CITY OF ALBUQUERQUE

March 3, 2011

Re: Certification Submittal for a Permanent Building Certificate of Occupancy (C.O.)
for **Lomas Car Wash**, [J-20 / D003]
9939 Lomas NE
Engineer's Stamp Dated 03/02/11

| ENGINEER'S SEAL            | <b>LOMAS CAR WASH</b><br><b>GRADING AND DRAINAGE PLAN</b>                       | DRAWN BY WCUJ         |

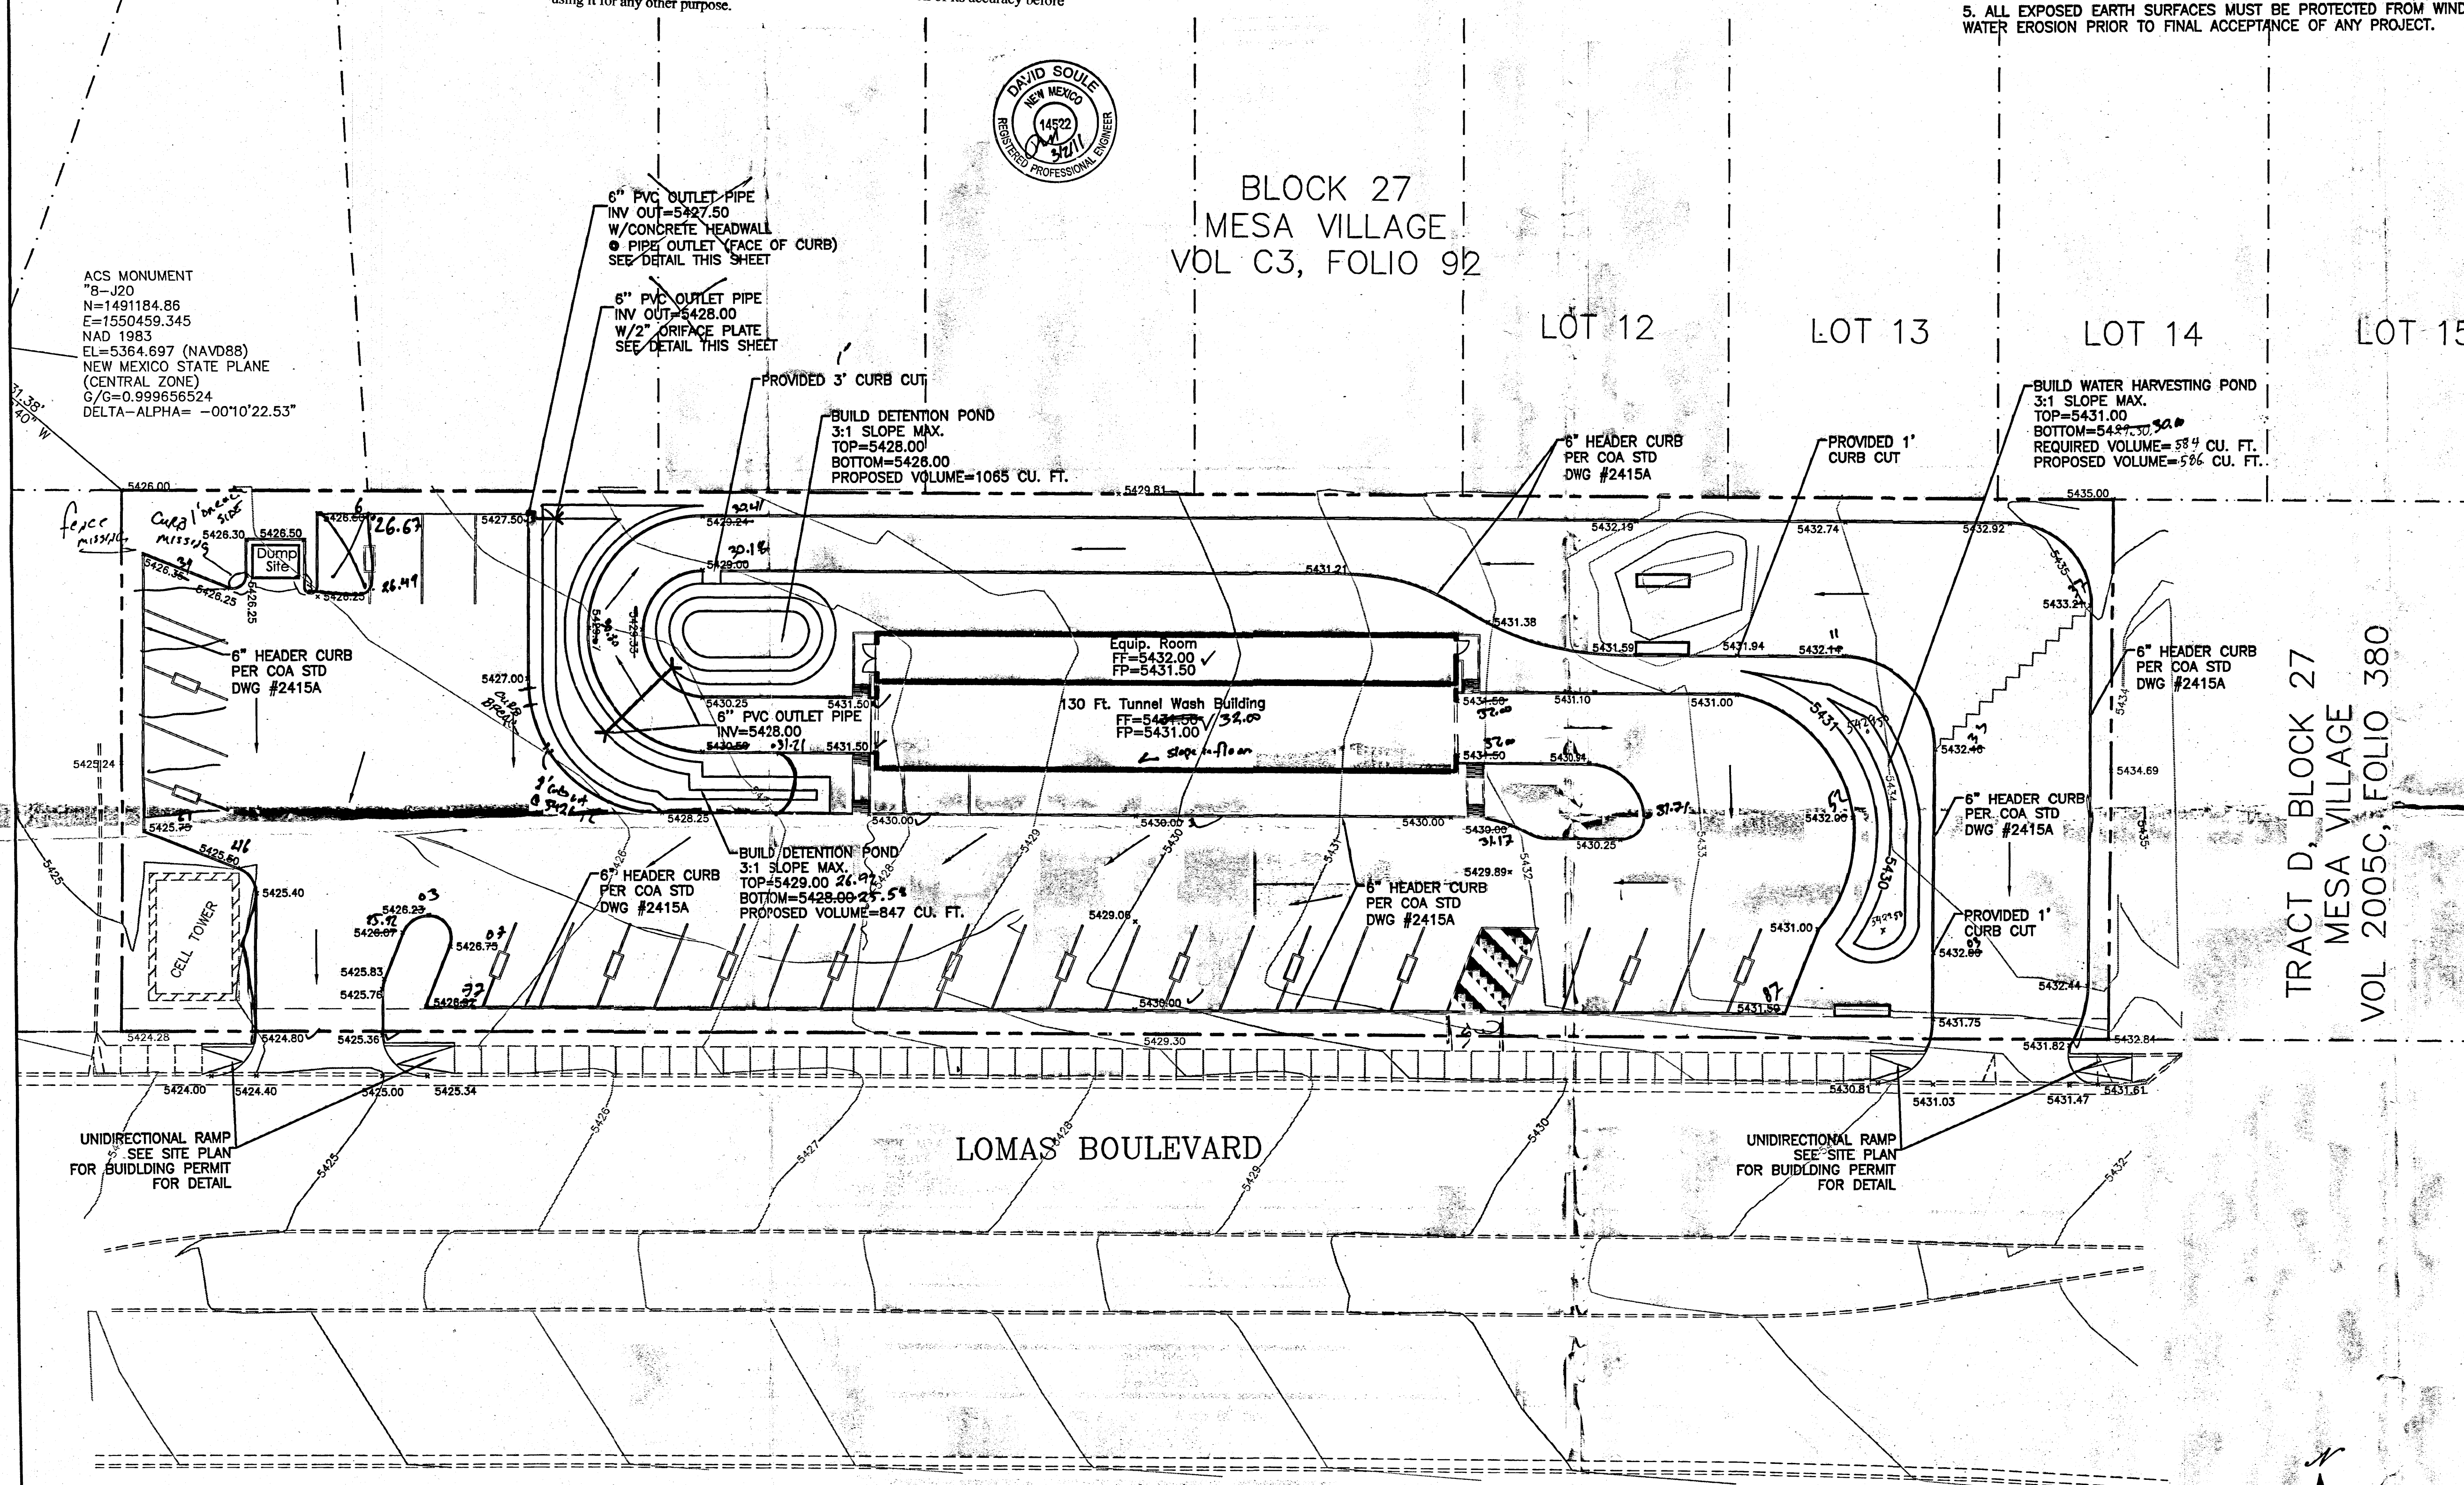
Is curbing provided throughout the site, if so what is top of curb?

How is 6" pipe placed?

Can .5 cfs be retained in the landscape areas?

The 5029 contour at the west end of building...needs clarification

Spot Elevation 5431.18 should be 5431.38

6" header curb has been labeled.

The pipe has been detailed.

Plan has been modified. The existing conditions have been adjusted to better describe the site as it is. A water harvesting pond has been added to capture a portion of the pavement; this reduces the increase flow to only .08 cfs, which is negligible. A modified spreadsheet has been enclosed to show the effect and required volumes of the landscape pond.

This has been corrected.

This has been corrected.

**UNI-DIRECTIONAL WHEELCHAIR RAMP W/EX. POLE DETAIL**

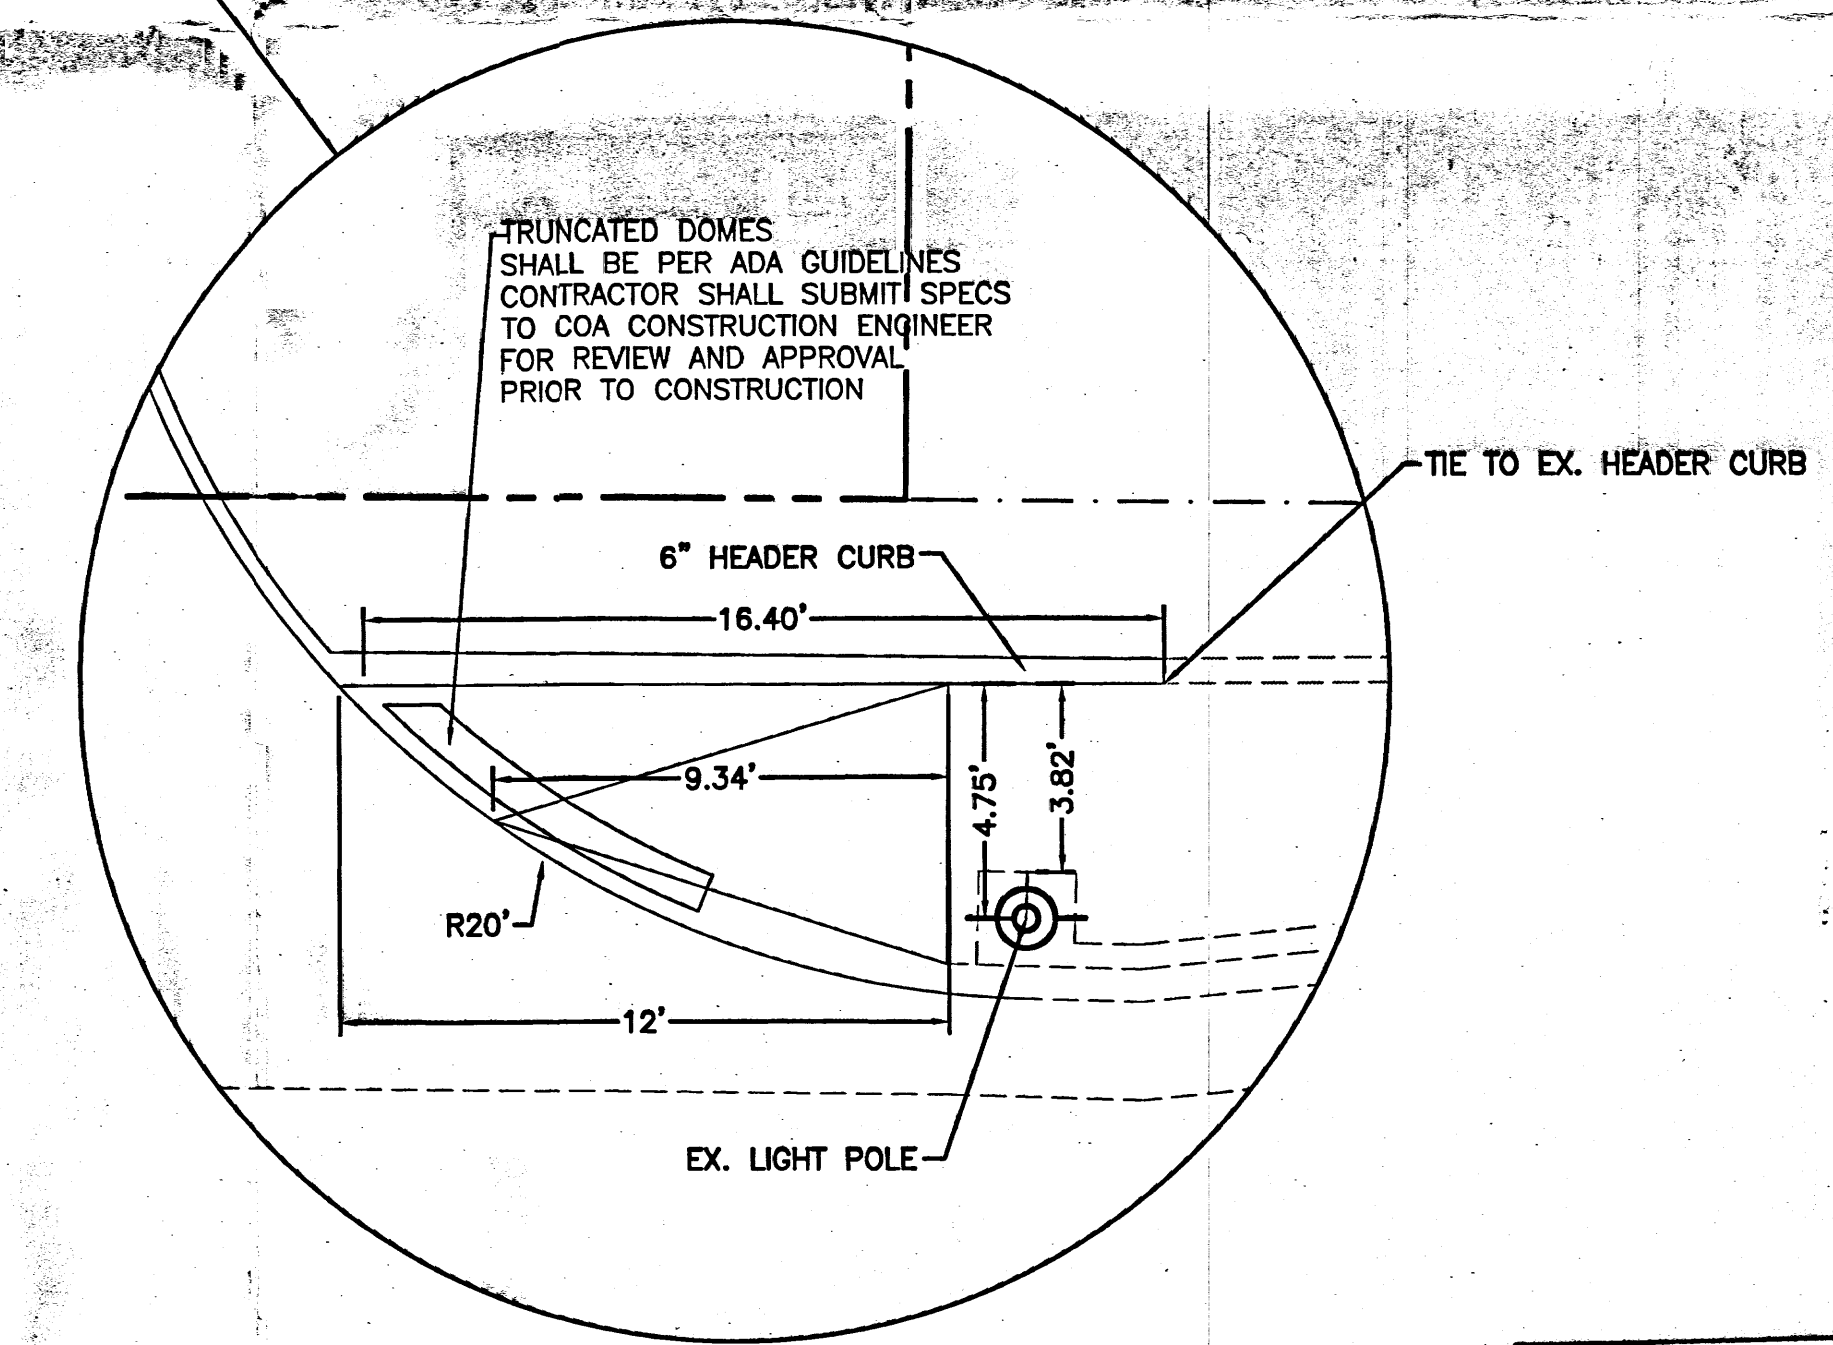
1. All ramps located in City of Albuquerque right of way must have truncated domes. Please add truncated domes to the detail titled "Uni-Directional Wheelchair Ramp w/ Ex. Pole Detail" or add a general note.
2. Clearly show the 6 foot wide, ADA accessible, pedestrian connection from Lomas Blvd. to the building. Show all ramps, if needed, and provide details. Please note that the connection is concrete from Lomas to the handicapped access aisle.
3. The pedestrian pathway from the handicapped access aisle to the building must be to scale. Please clarify if a ramp is required, as well as defining what is located both east and west of the proposed carwash. Are these stairs?
